Harnett County

Permit Number: BCOM2603-0001

Description: 11750 sqft. JWR Ventures Manufacturing Building

LIST OF REVIEWS

S4.1

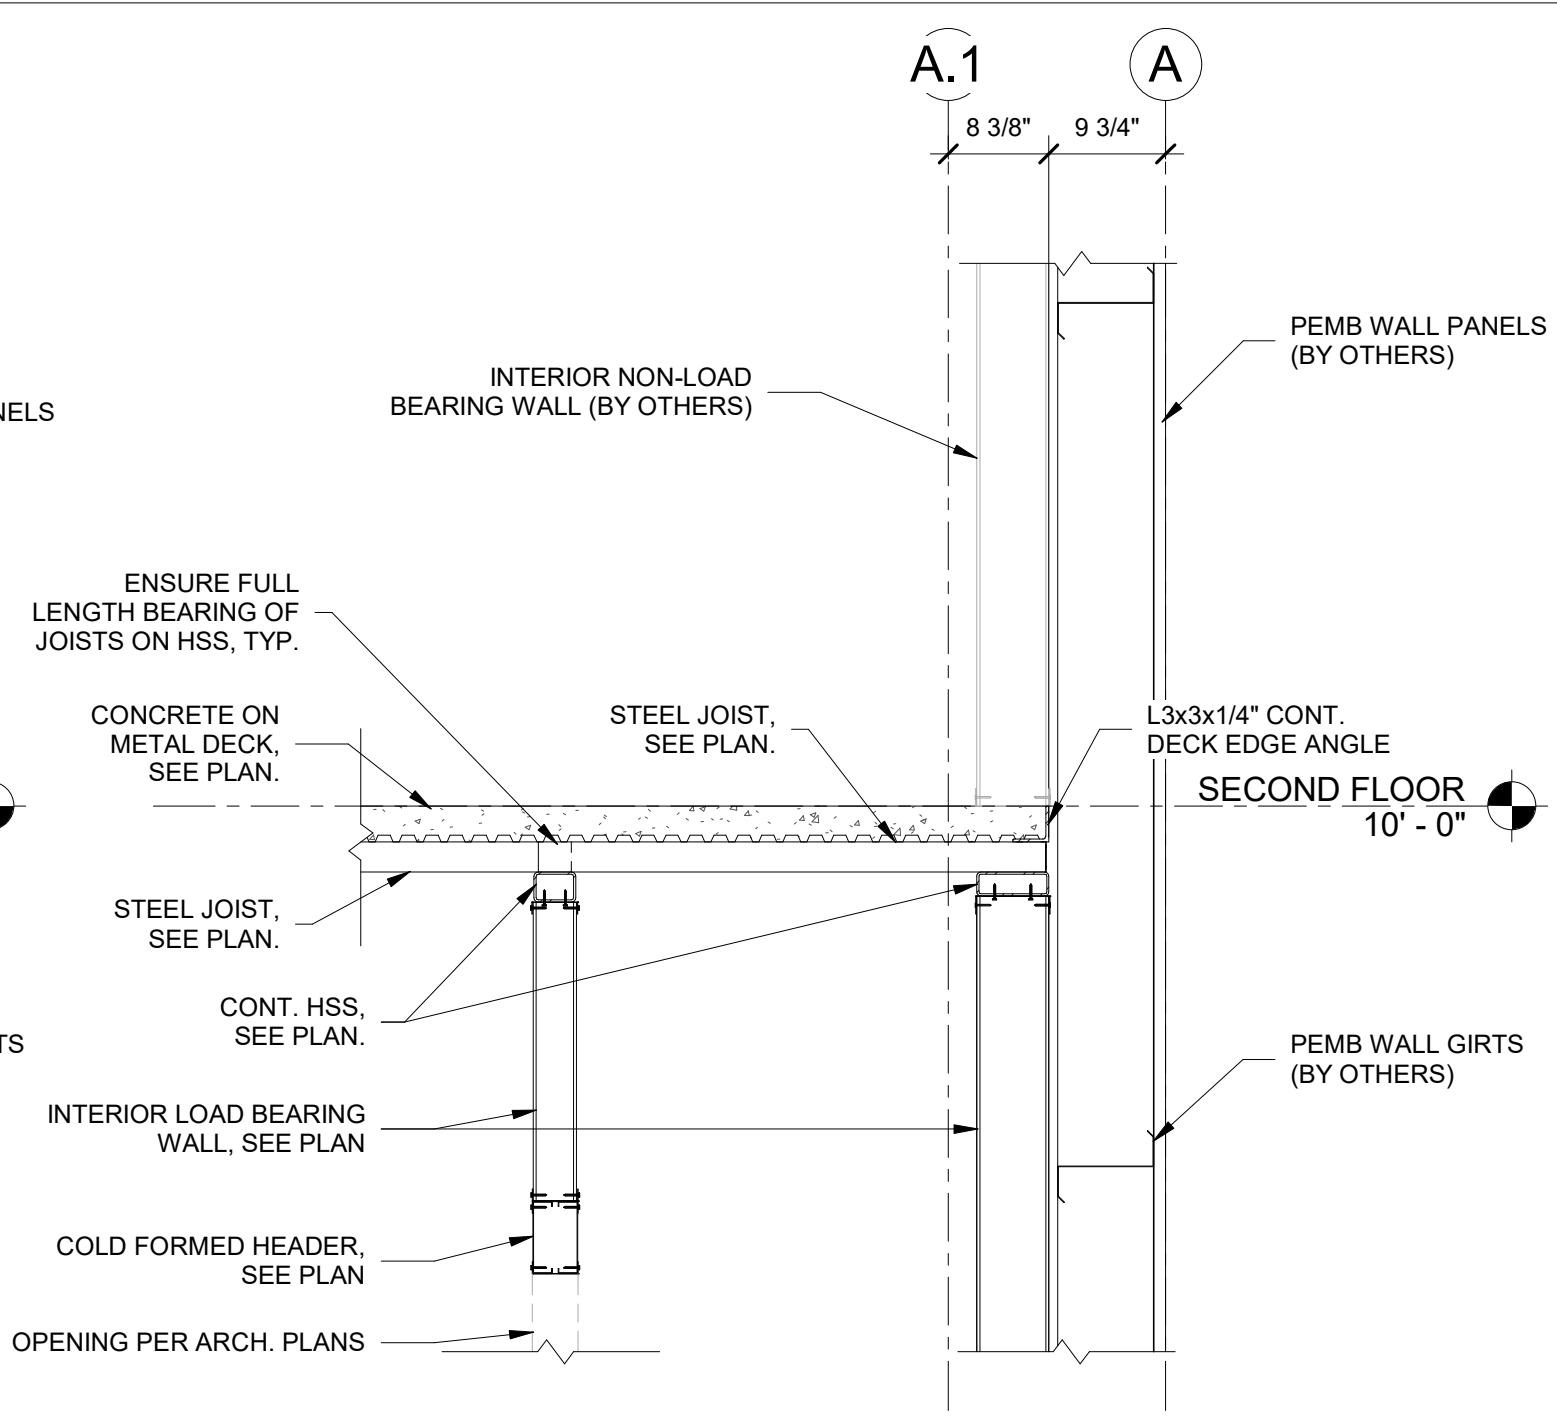
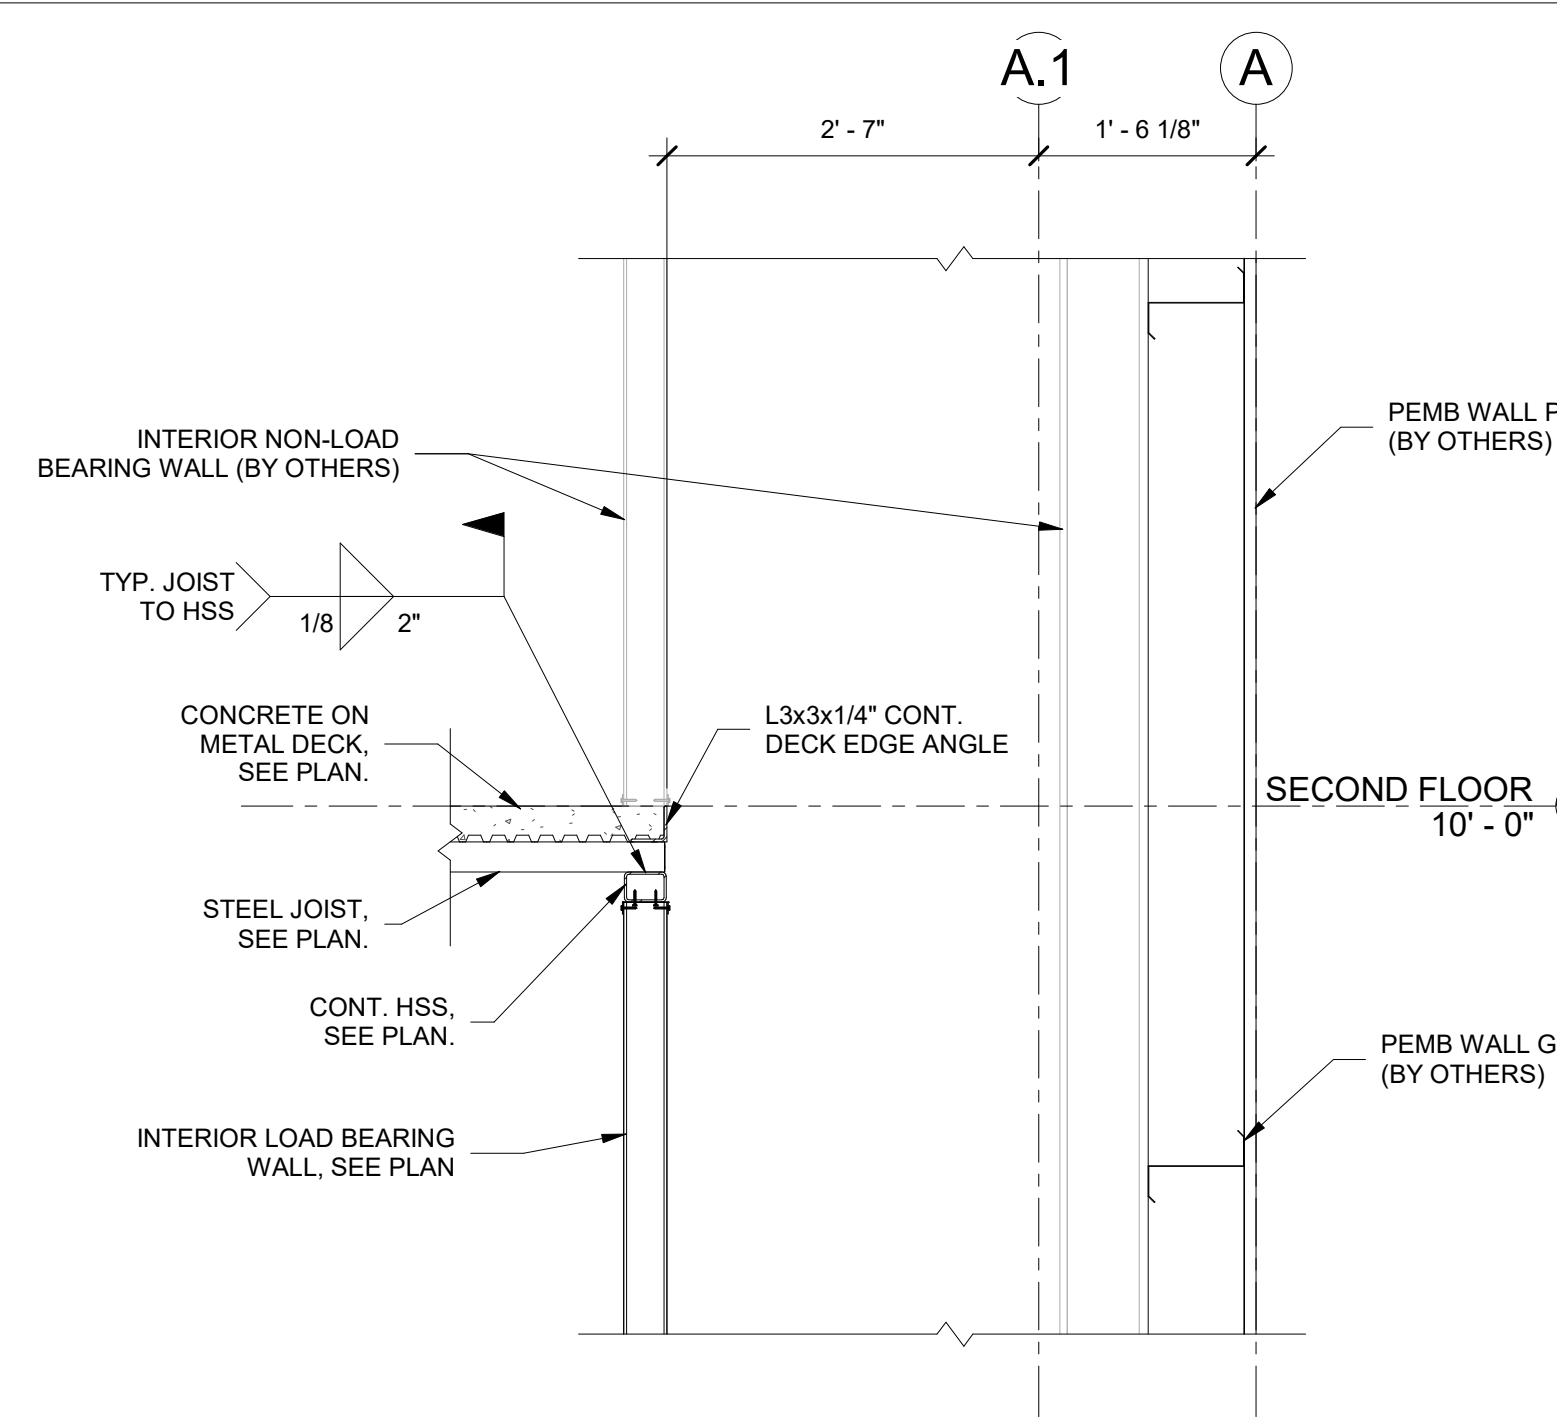
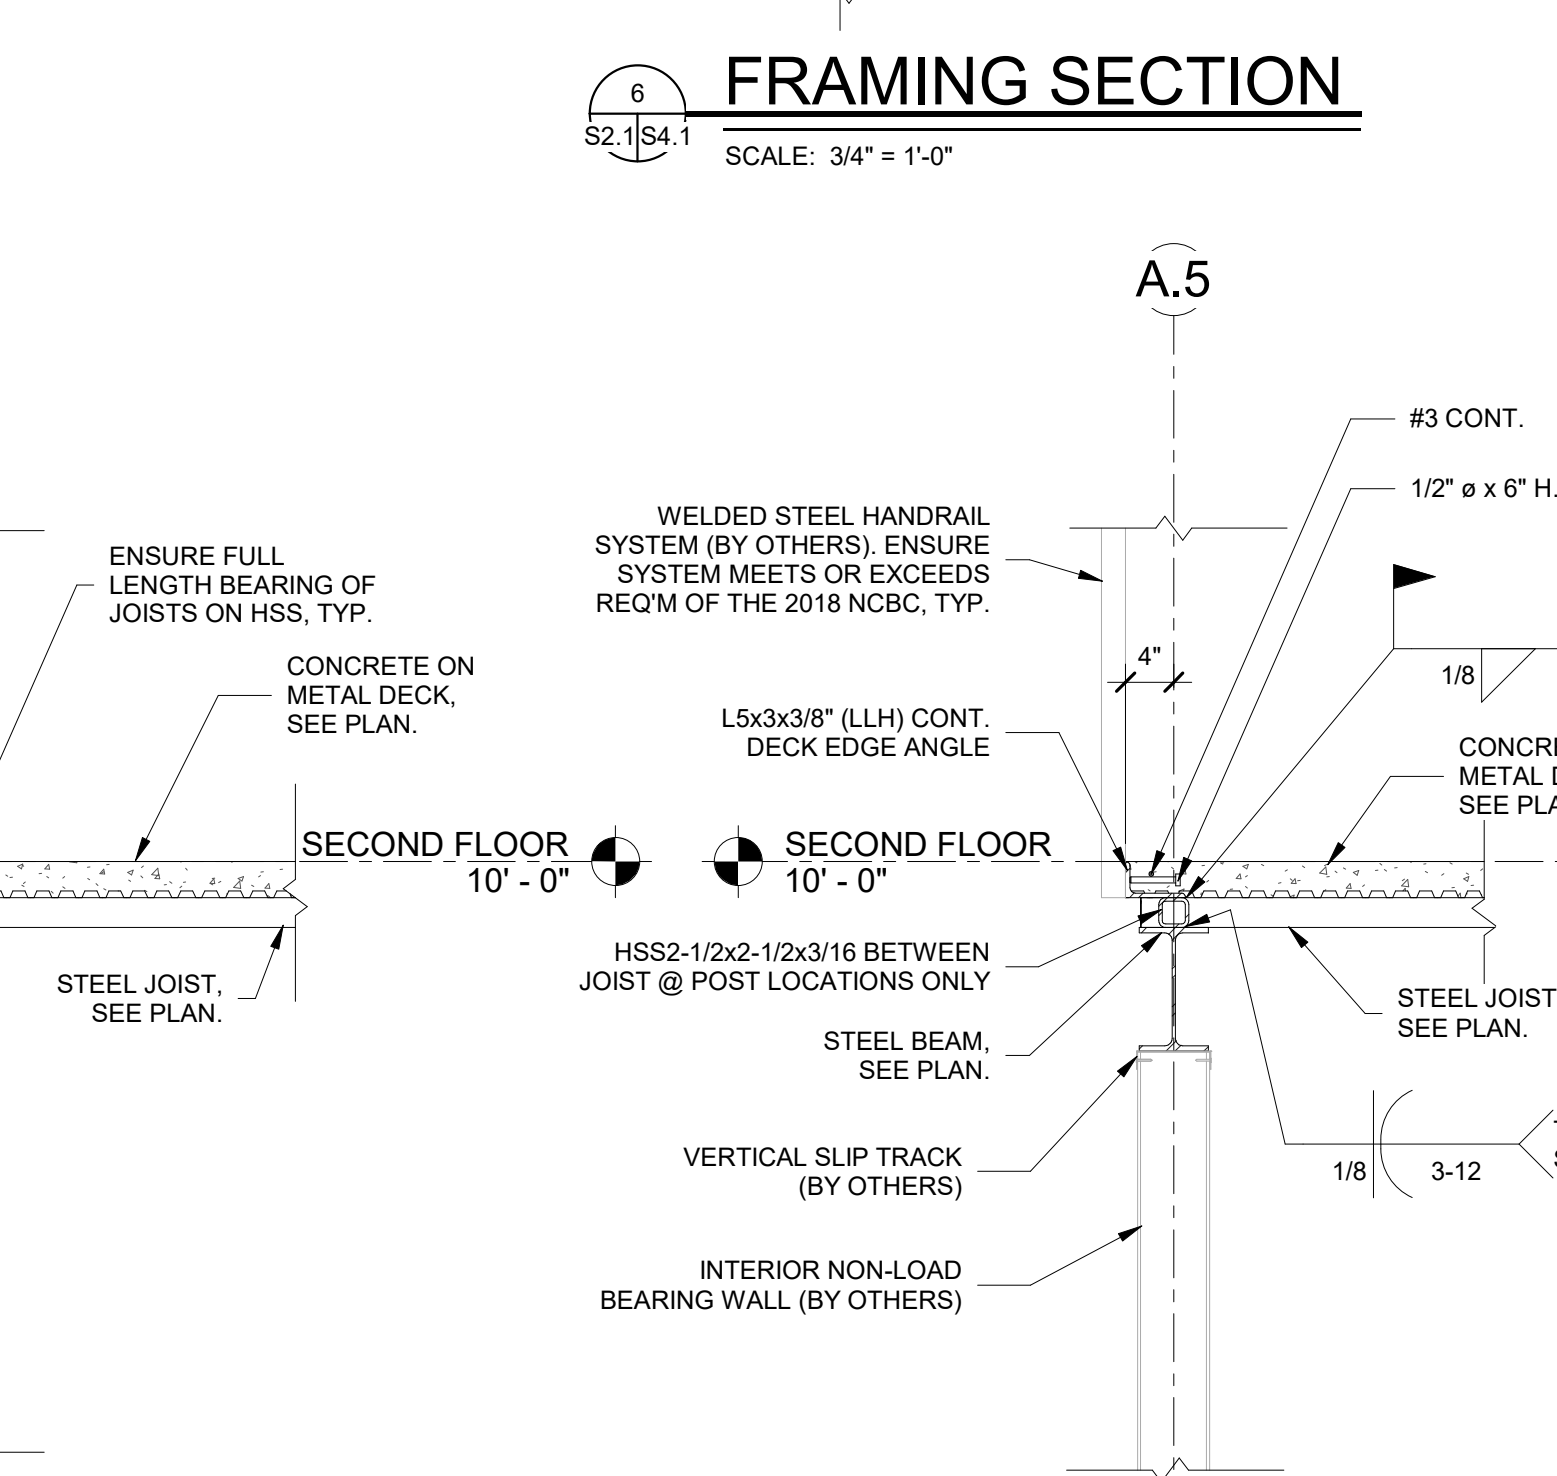
1. Provide information on floor sheathing detail 6 S4.1 penetrating 2 hour wall. 2. Provide information on electrical installation of devices in 3 hour wall. 714.3.2 allows installation in 2 hour wall max. 3. Provide UL details of through penetrations to be used on 3 hour wall for all trades.
